Eastern Creek Business Hub Retail Centre

*State Significant
Development
Modification Assessment
(SSD 8588 MOD 3)*

November 2019

6 ELEVATION - SIGNS N AND O  
A3010 1:100

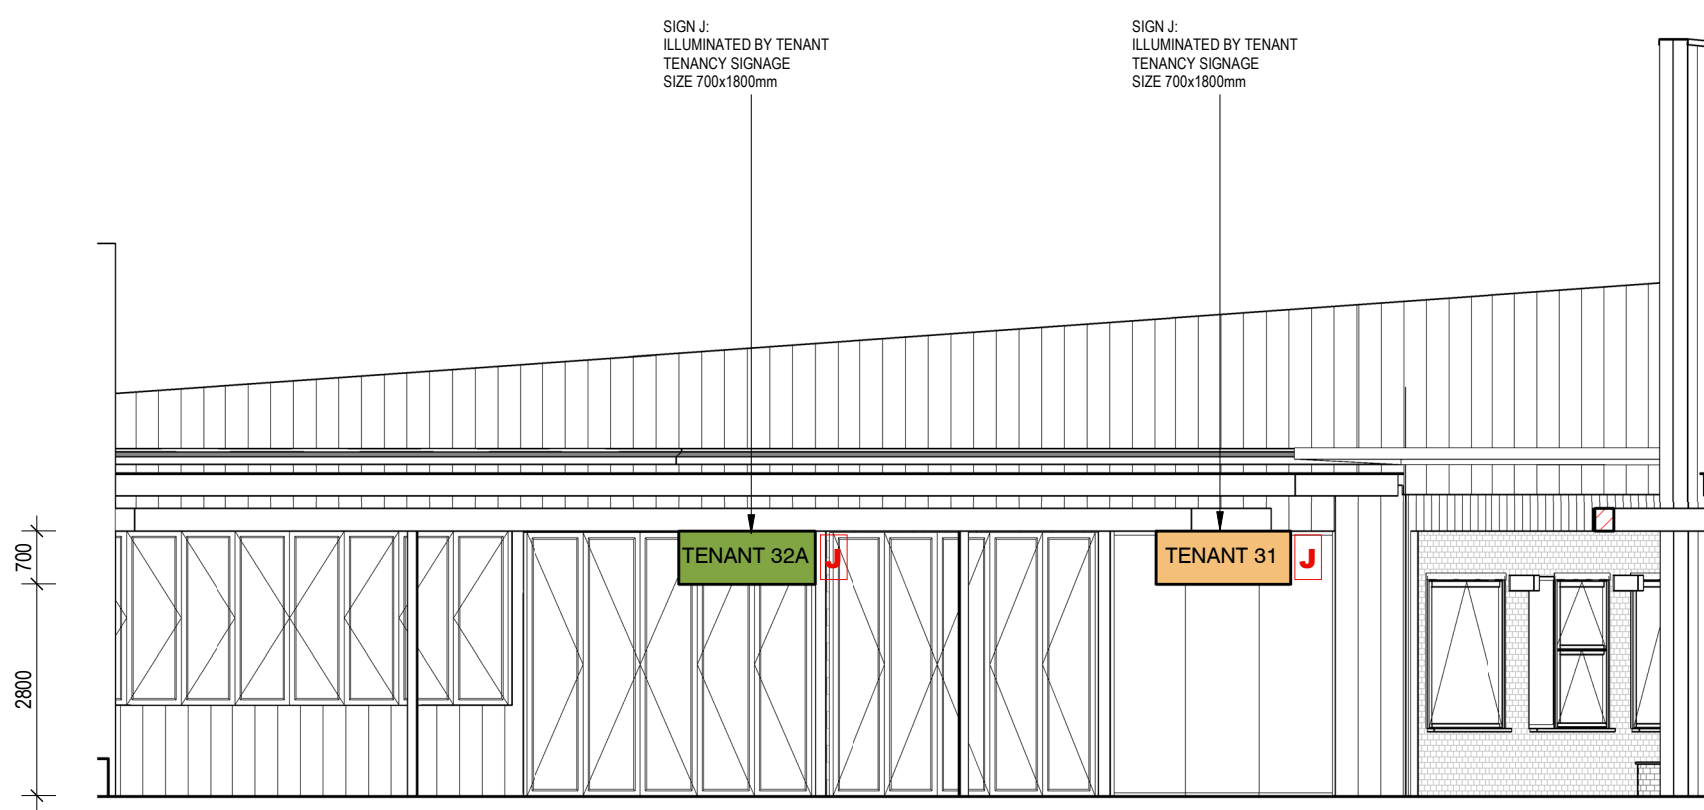
Signs N and O are anchor tenant signs located on the western facing elevation of the retail centre, directly behind a residential dwelling at the corner of RHRS and Beggs Road (**Figures 6 and 7**). The Department raised concerns about adverse amenity impacts from these two signs to the residential dwelling and requested the Applicant consider relocation or provide justification for the location of these signs.

In response the Applicant amended the proposal and provided further information in relation to signs N and O including:

- removal of illumination
- planting of two advanced growth *Cupaniopsis anacardioides* trees in the deep soil zone adjacent to the rear of the residential dwelling.

The Department has considered the Applicant's response and supports the changes to signs N and O for the following reasons:

The Department recommends two new conditions prohibiting any illumination of signs N and O and requiring two advanced growth *Cupaniopsis anacardioides* trees to be planted.

FLOOR PLAN - PARKING AREA SHADE SAILS 1 : 200

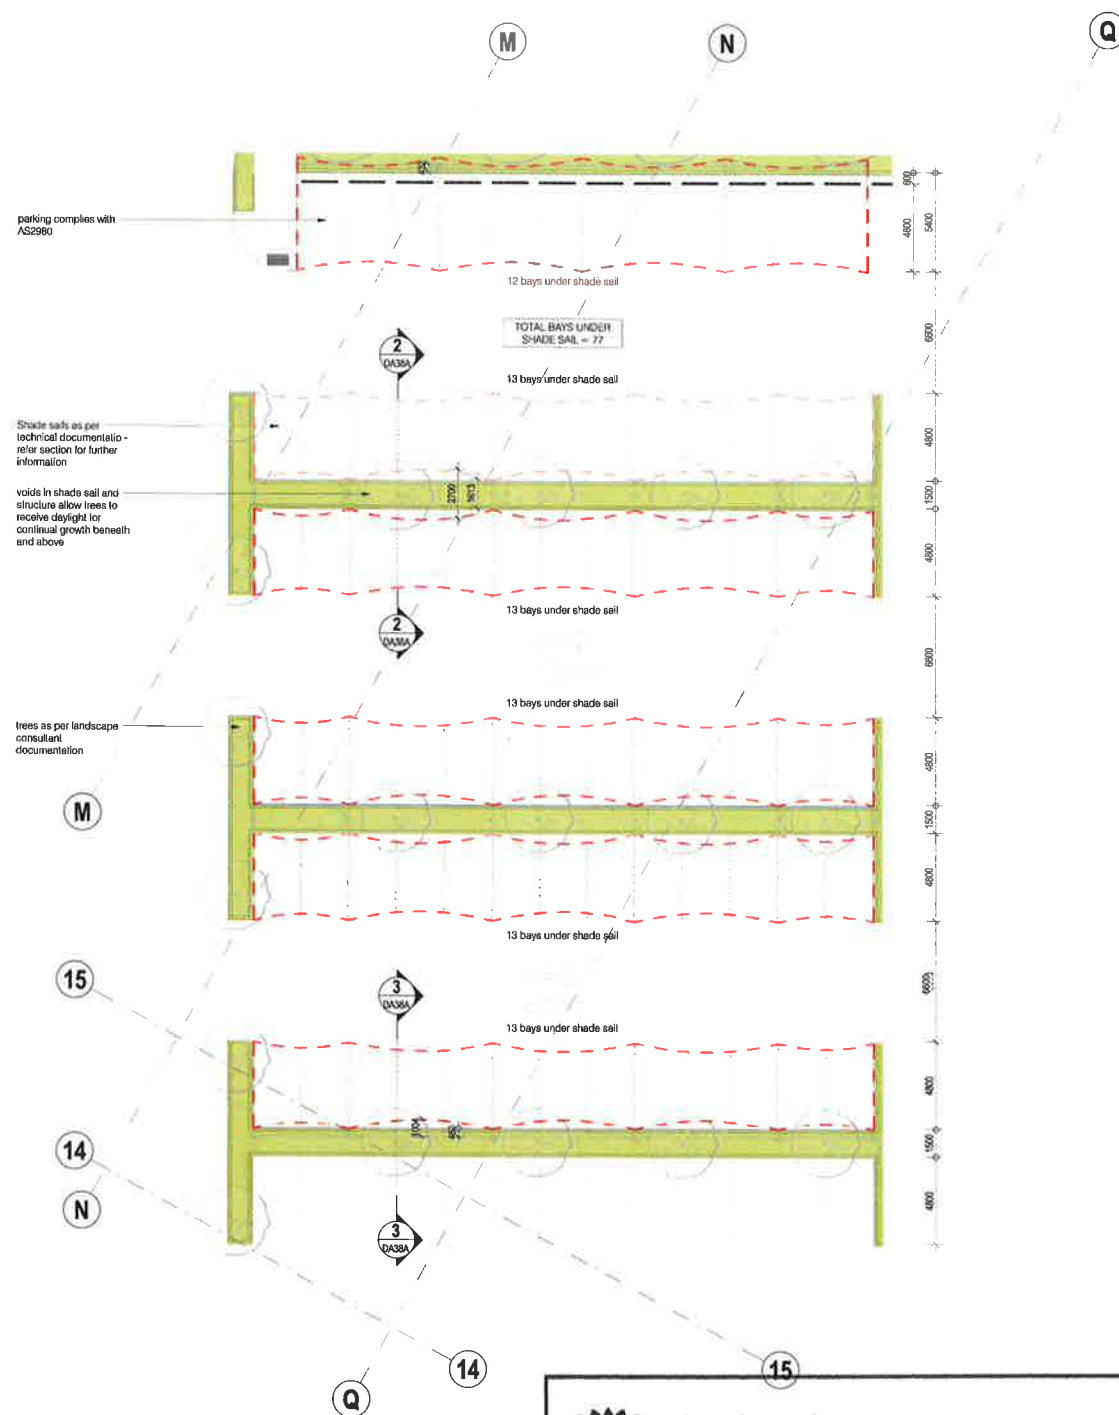
In response to the Department's request for information about how the shade sails will integrate with the carpark landscaping, the Applicant, in its RTS, provided a statement from a landscape architect and a shade sail landscape plan.

The Department is satisfied the shade sails will integrate with the tree planting and landscaping in the carpark as:

- advice from a certified landscape designer has been provided confirming there is sufficient space to plant seven Spotted Gum Trees in each landscaping row between the car spaces (as per the approved landscape plan) and the void between the shade sails will enable tree growth, subject to a maintenance schedule to monitor tree branches during establishment of the mature trees (**Figure 9**)

The Department recommends that Condition B5 (detailed landscape plan) is amended to require the landscaping maintenance schedule be updated to include the requirement to monitor the trees planted in the shade sail carpark void. Subject to this, the Department is satisfied with the addition of shade sails to the carpark.
